Your Ref: ABP- 314232-22

**Re: Railway Order Application– Regarding the proposed DART+ West Railway Order  
- Dublin City to Maynooth and M3 Parkway**

Irish Water (IW) has reviewed the plans and particulars listed online for the subject Railway Order Application, and based on the information published online ([www.dartplus.ie](http://www.dartplus.ie)), with specific regard to the Planning Report, Chapter 10 (Water) & 11 (Hydrology) of the Environmental Impact Assessment Report (EIAR) and the planning application Drawings and Maps, IW have the following comments:

UTILITIES DIVERSIONS  
OBG-18  
TRACK LOWERING

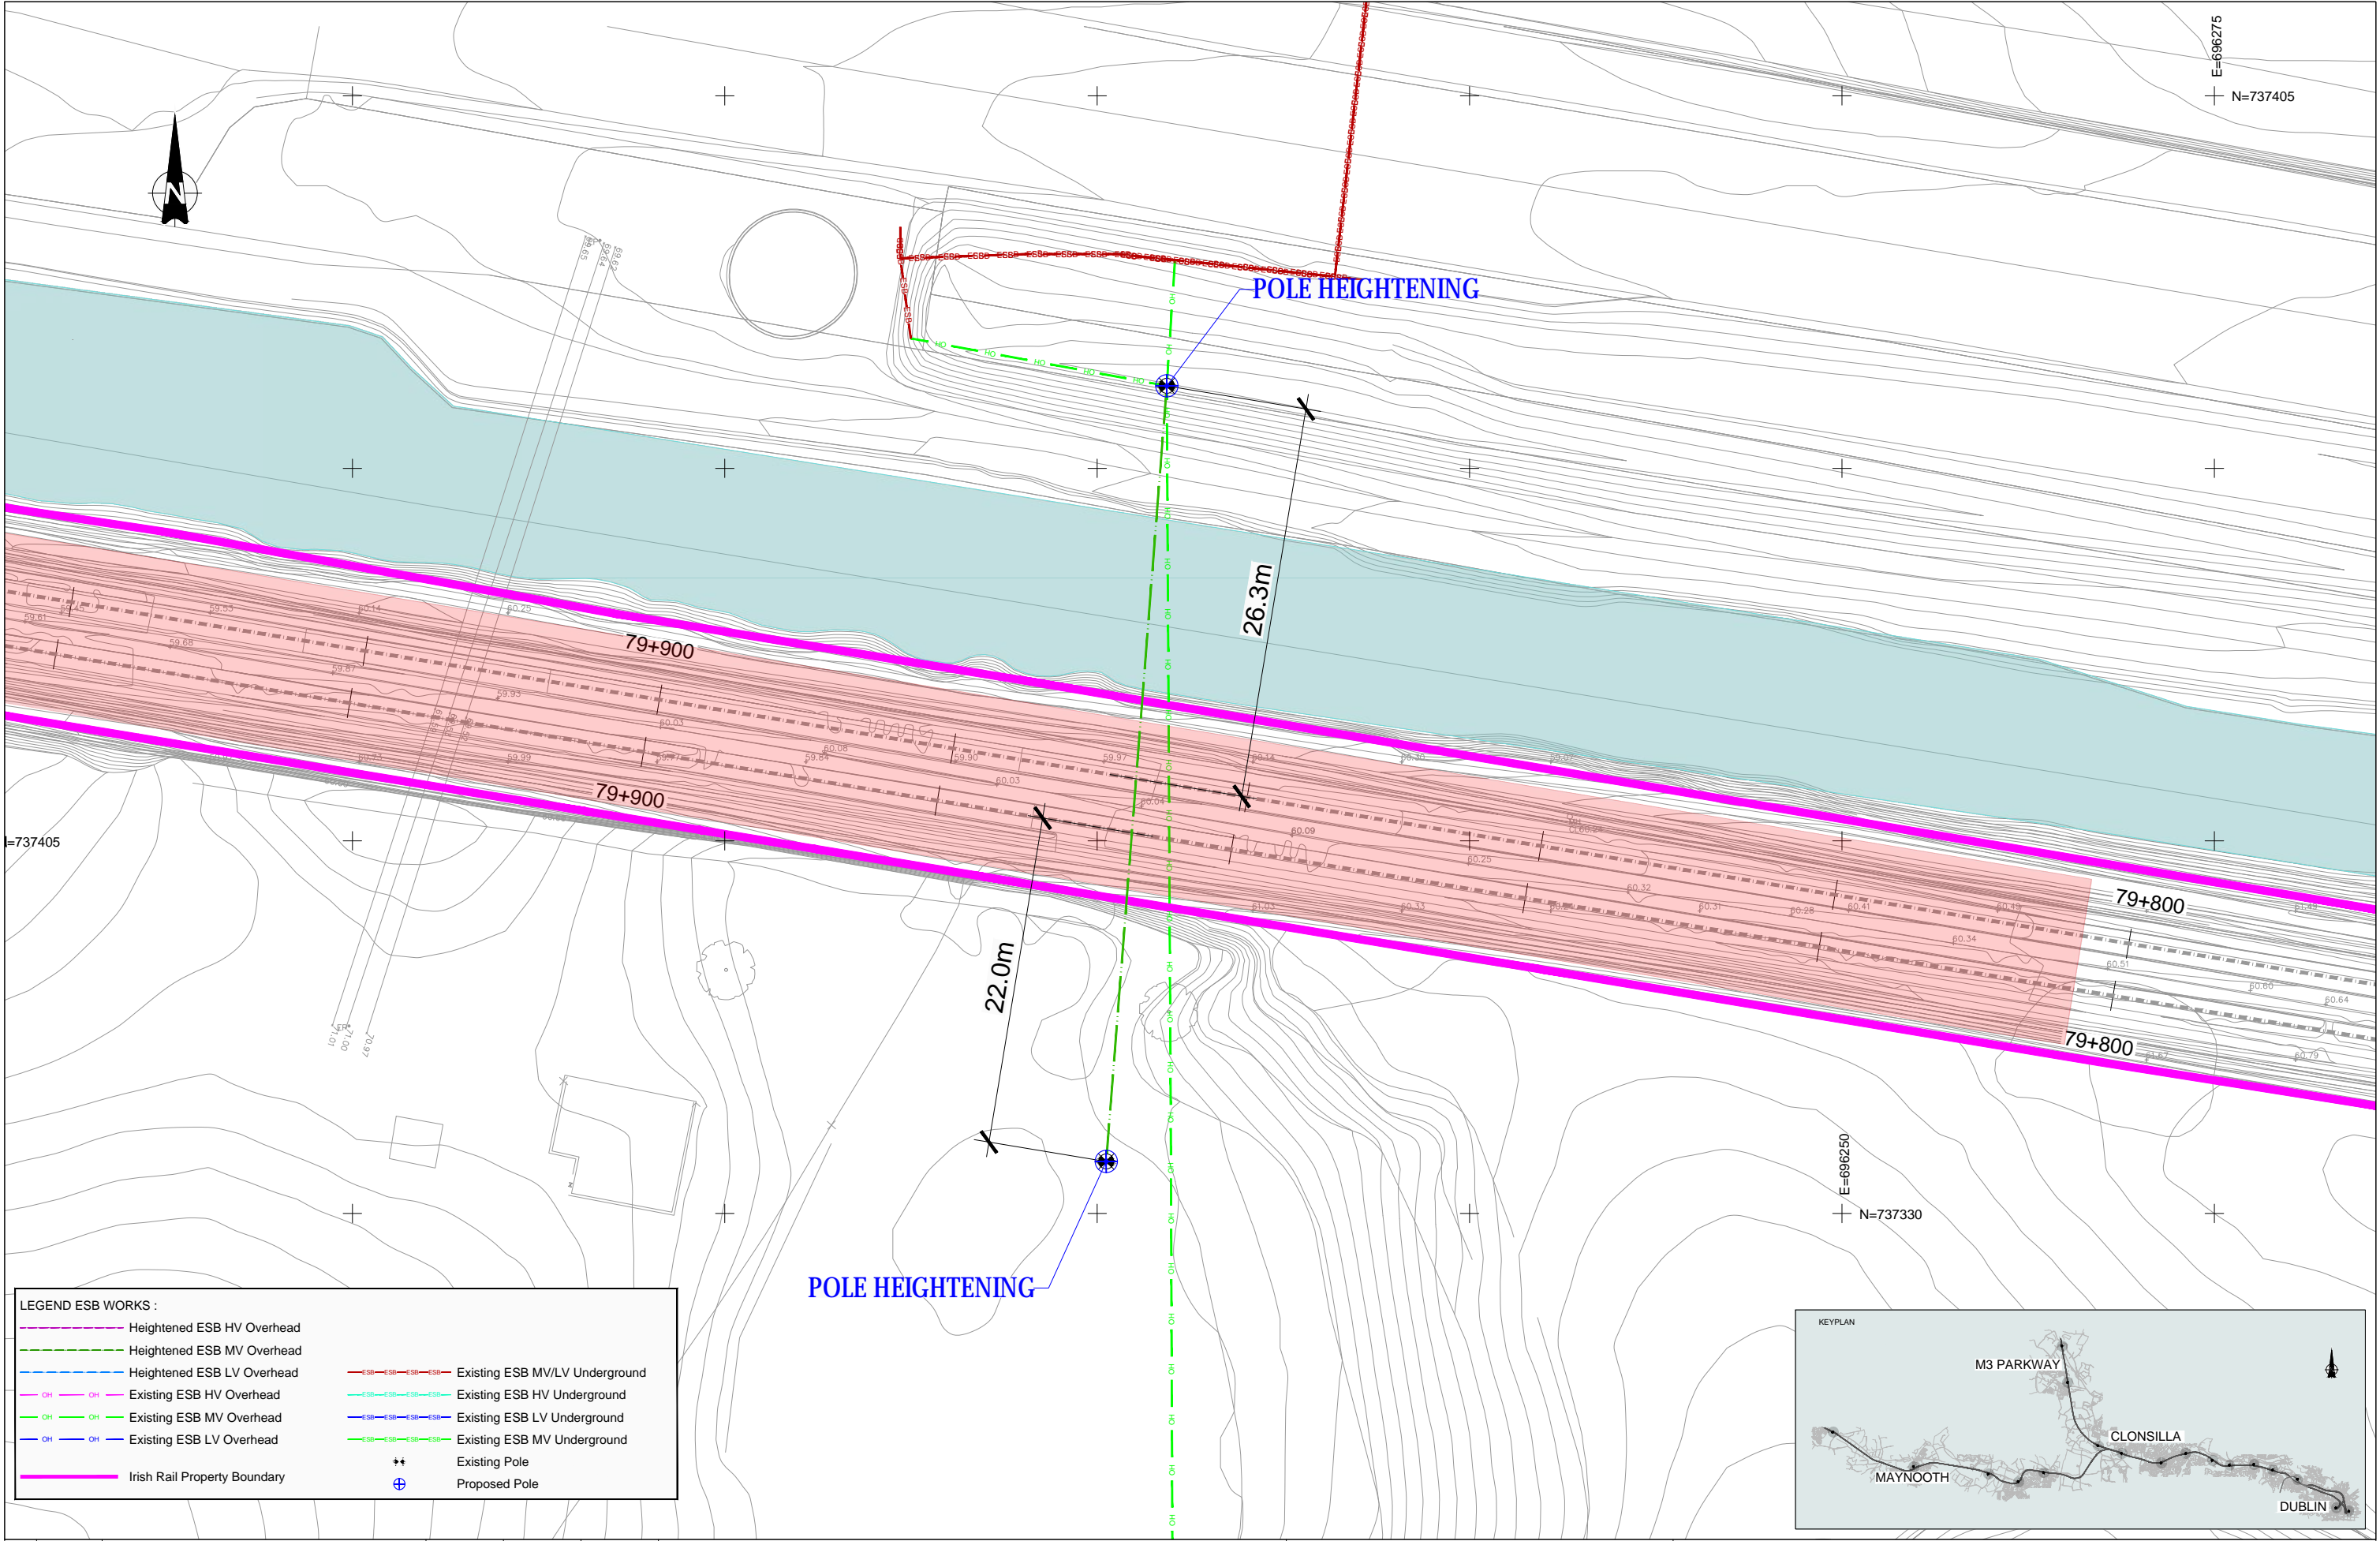
#	Reference	Section of existing pipe under track lowering			Irish Grid coordinates
		Diameter (mm)	Material	Length under tracks (m)	
1	OBCN290 (Water)	100	PVC	8	302128, 241754
2		200	PVC	8	302128, 241754
3	OBCN290 (Gravity Foul)	450	CO	22	302134, 241706
4	OBD221-222 (Water)	50.88	CI	17	315016, 236317
5	OBD223 (Water)	101.6	DI	11	315903, 235996
6	OBD226 (Gravity Foul)	550	CI	13	316932, 235476
7		900	CI	16	317008, 235400
8	OBG21 (Gravity Foul)	225	Concrete	18	293390, 237125
9		450	Concrete	18	293422, 237131
10	OBO36 (Gravity Foul)	375	CI	64	317303, 235110
11		1200	Brick	75	317301, 235096
12	OBO36 (Pumped Line)	400	CI	66	317303, 235110
13	OBG18	600	DI	14	296241, 237336
14		600	DI	14	296241, 237336

Conclusion: Based on the details provided by the applicant, IW confirm that subject to detailed design being agreed with IW for the above locations and valid agreements being put in place prior to the commencement of development, the subject development can be facilitated.
